RE: Intake Screening- 2206-040
Project: 9191 SE 64th st. new SFR.

Please find our responses to your intake comments:

APN: 302405-9001  
SITE DEVELOPMENT PLAN  
ALTMAN PARCEL A  
MERCER ISLAND, WASHINGTON  
ESTATE OF JAMES H. ALTMAN, SR.  
MERCER ISLAND, WASHINGTON 98040

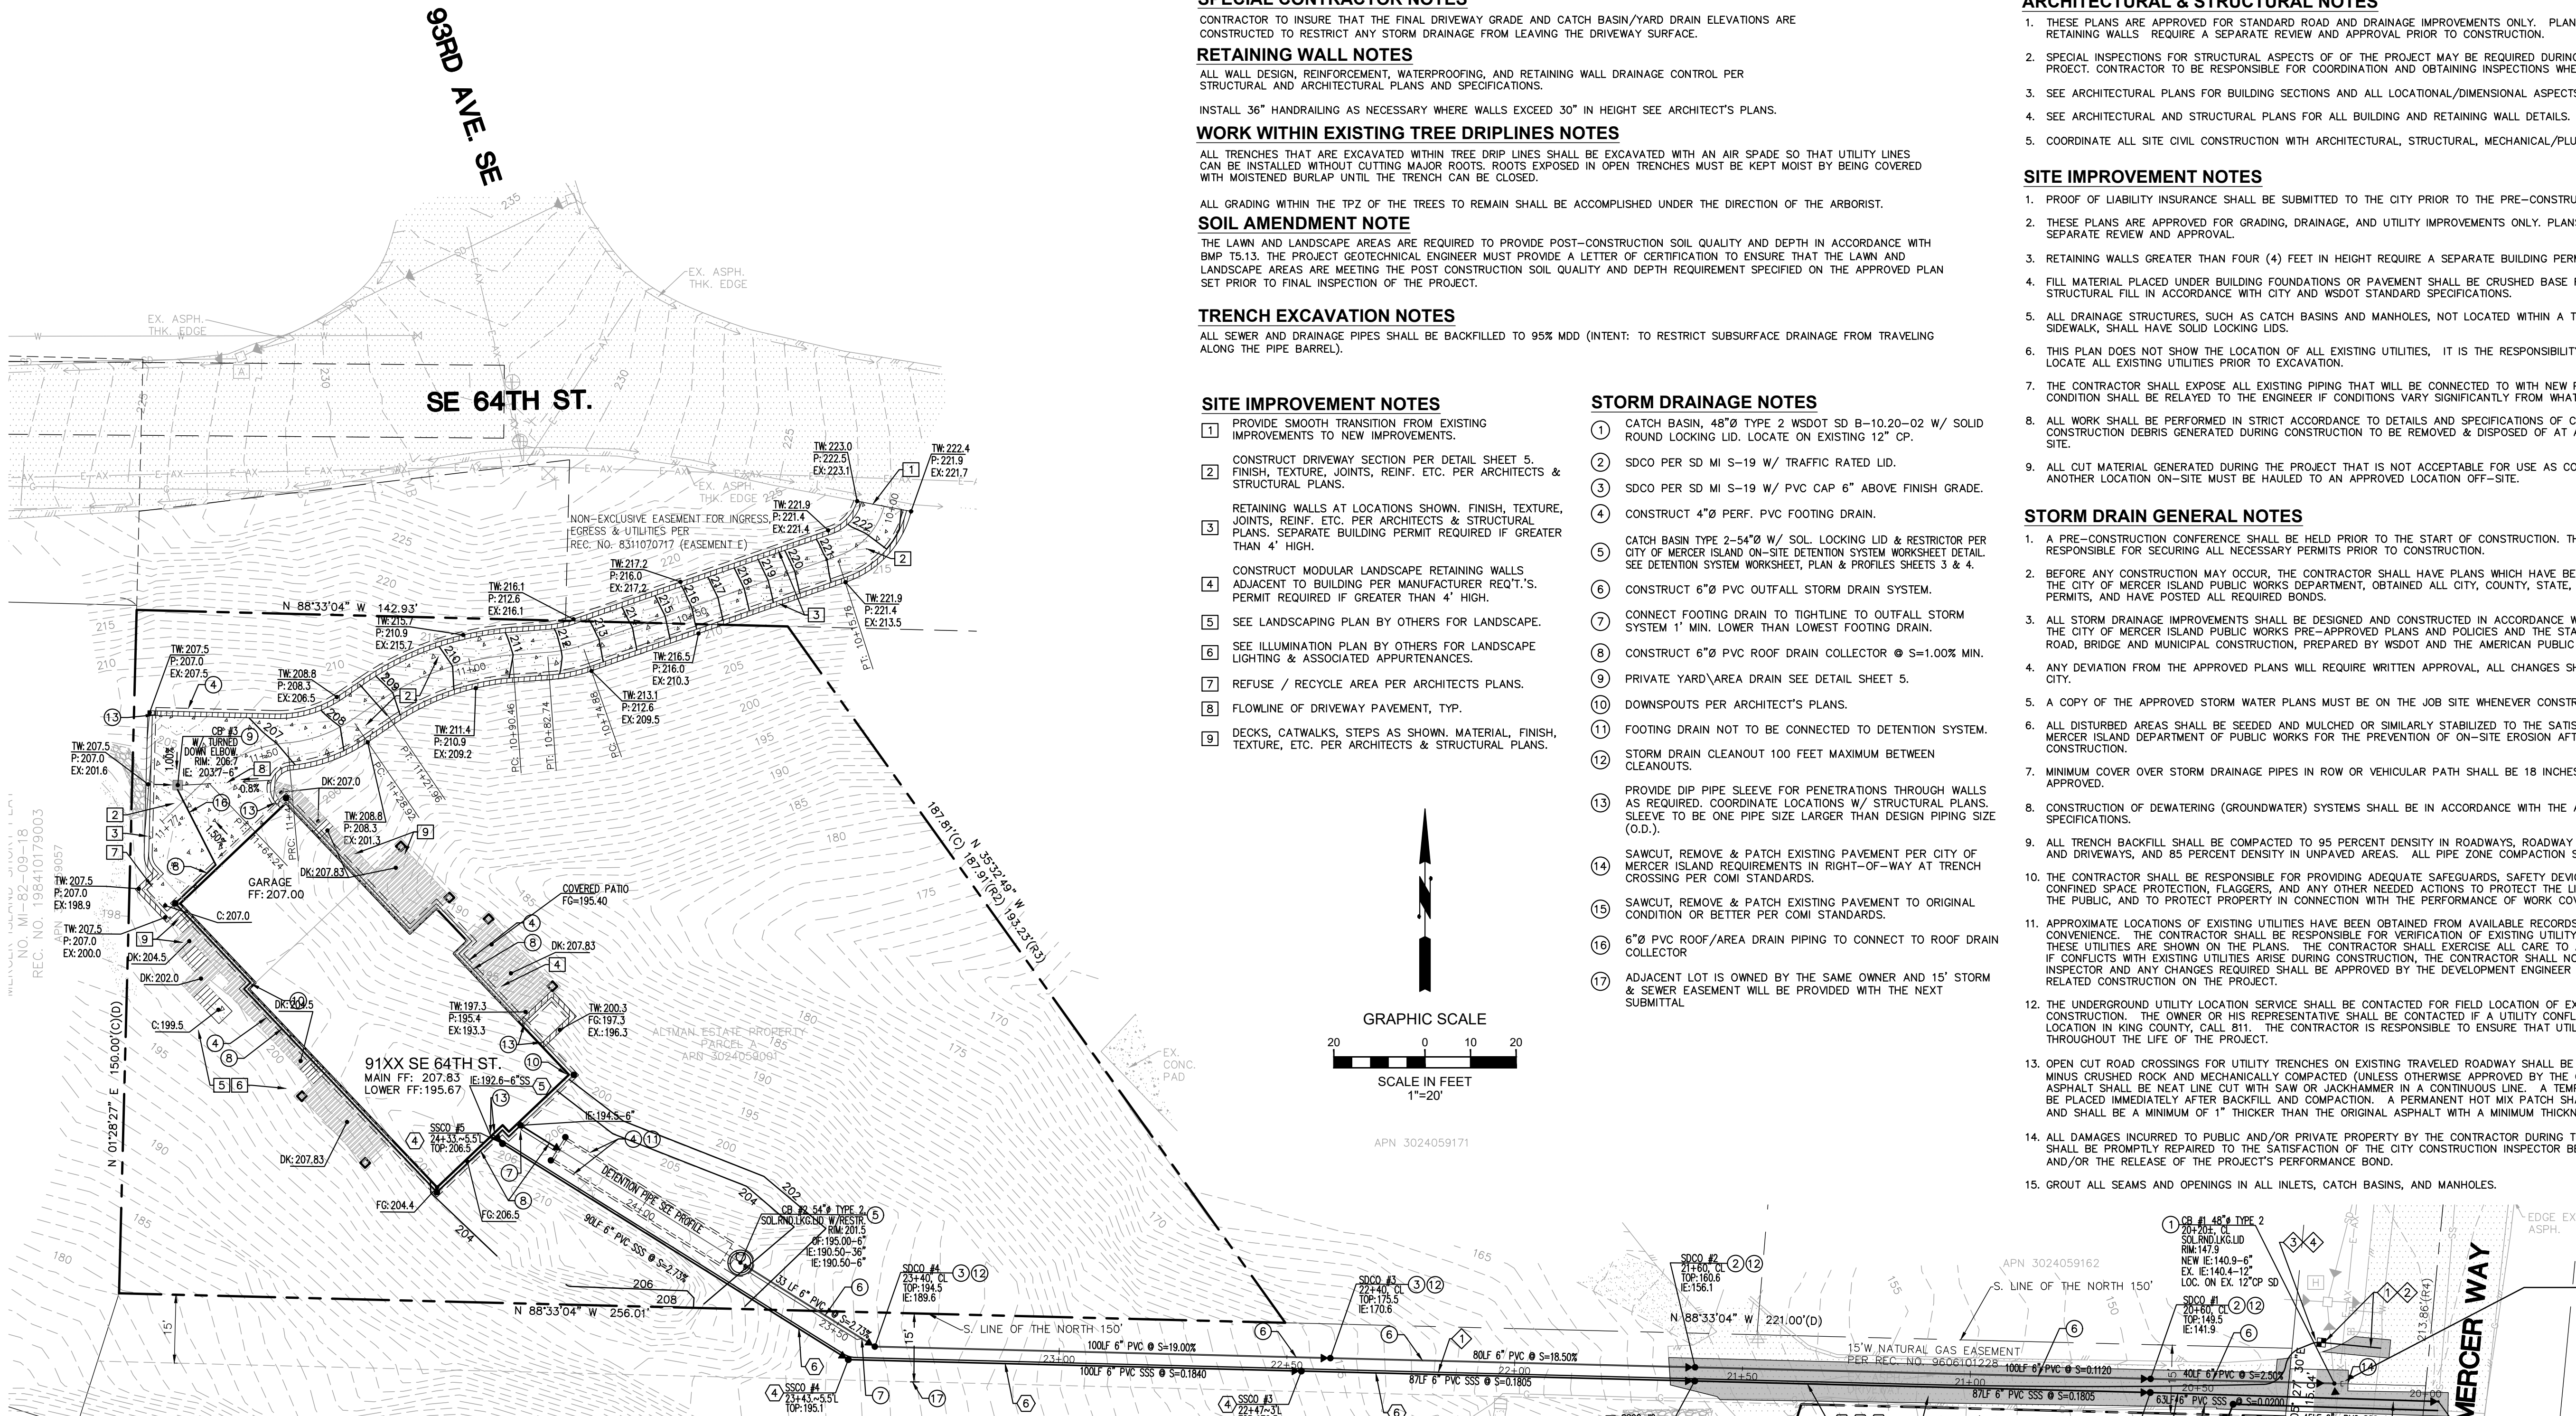
1. Ruji Ding-Civil plan shows proposed drainage system on neighboring property to south. Provide recorded easement or written agreement from property owner.
Written agreement for easement included in resubmittal docs. Property to the south is also owned by this property owner if that makes things easier.
2. Gareth Reece- Recommendations and design for a shoring wall are included in the supplemental documents, but these components need to be documented in the construction set.
Shoring wall docs added to the construction set.
